MEMORANDUM

TO: Bill Needelman, Planner
FROM: David Senus, P.E. & Ashley Auger, E.I.T.
DATE: November 27, 2012
RE: 40 West Commercial Street, Final Level III Site Plan Application

Woodard & Curran has reviewed the Final Level III Site Plan Application for Phase I of the Canal Landing Development at 40 West Commercial Street in Portland, Maine. The project proposes to construct a boat repair and maintenance yard, along with related marine uses over the course of multiple phases. Phase I will include construction of a 19,200 Square-Foot tension fabric building and associated utilities, concrete boat ramps along the shorefront, establishment of yard areas, and marine improvements.

DESIGNED BY: CMW  
 CHECKED BY: SRB  
 FILE NAME: 3091.02-GRADING  
 SHEET: C-3.1

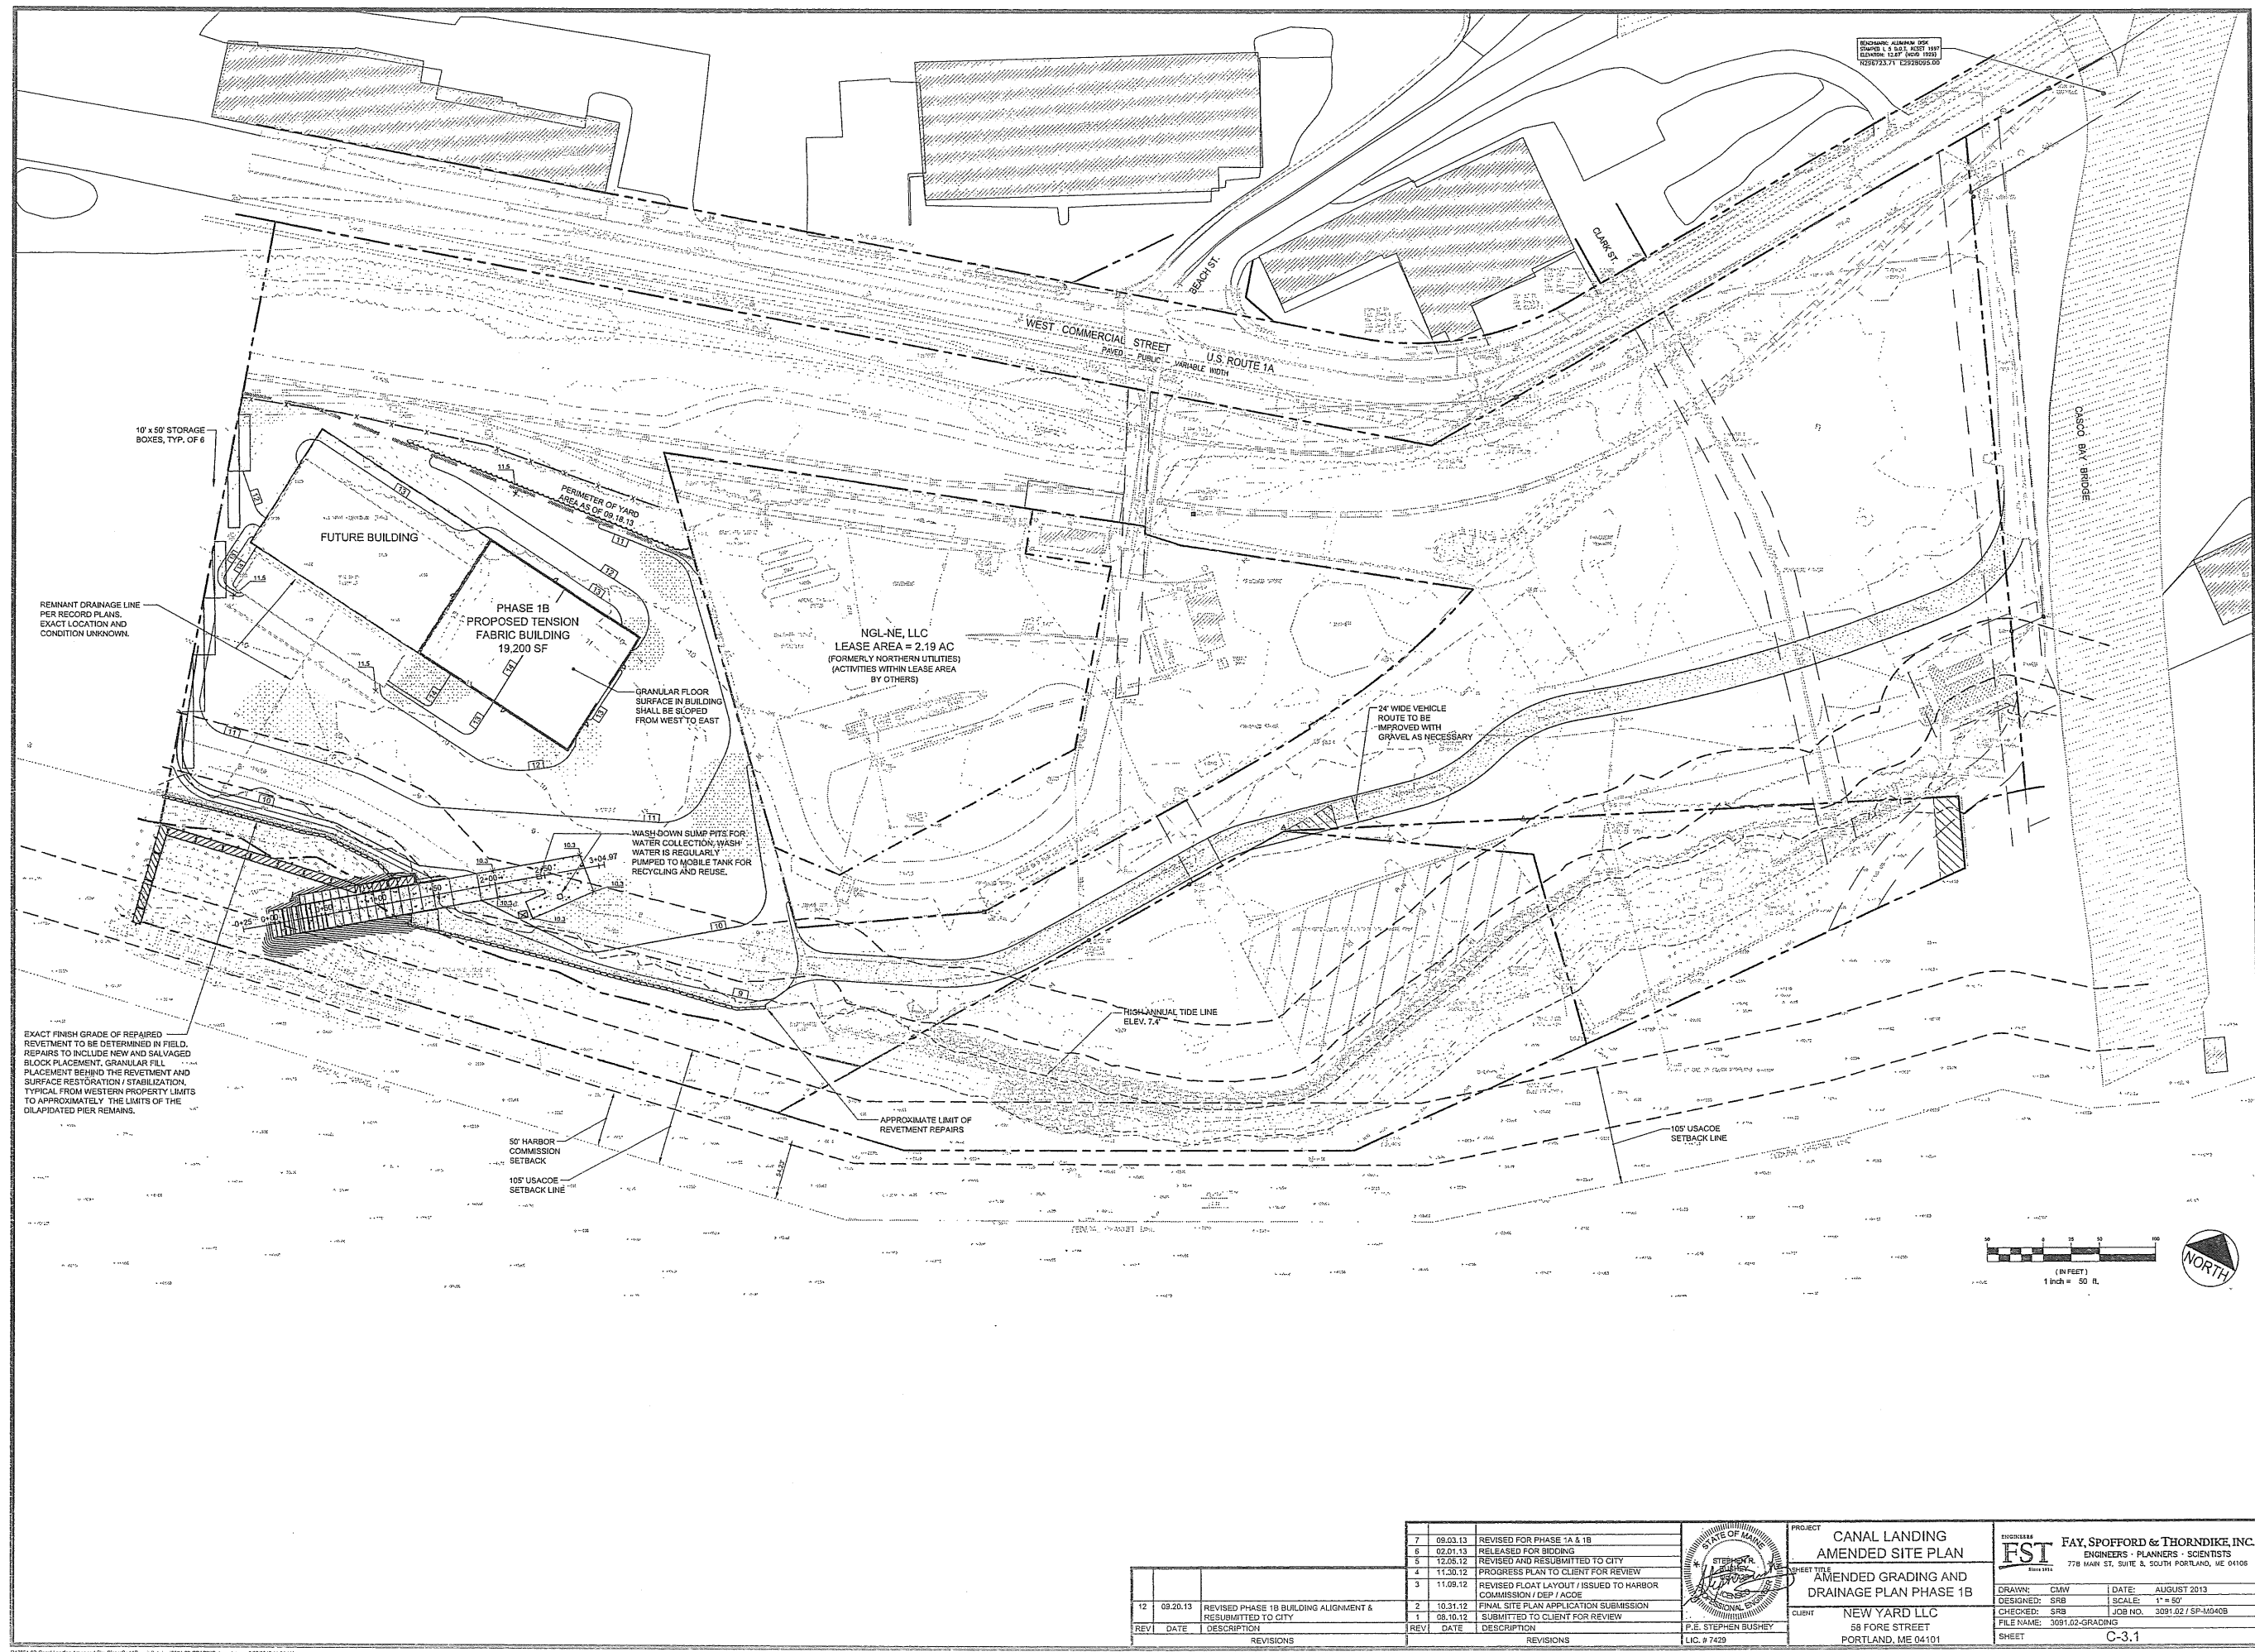
- iv) Please provide additional details identifying surface preparation, materials of construction, and surface vegetation for the "Stormwater Management Areas" noted on C3.1.

- v) Three "Washdown Collection" areas with "Washdown Collection Inlets" are proposed in proximity to the marine access ramps. Please provide additional information on these collection areas, including detailed grading for the washdown areas associated with inlet "G1" and inlet "F1", and information on the function and design of the inlets (Where do they discharge to? If they store water, what is their capacity and how frequently will they be cleaned/drained?).

- 4) The plans should include notes related to the size, slope, elevation and material for all stormwater drain pipes proposed on the project.
 - 5) The proposed 12"x24"x24" tee connection from "Overflow Structure D1" to the 24" RCP sewer on sheet C3.1 is not an acceptable means of connecting to the City's sewer/drain infrastructure. A connection of this size will require a manhole.
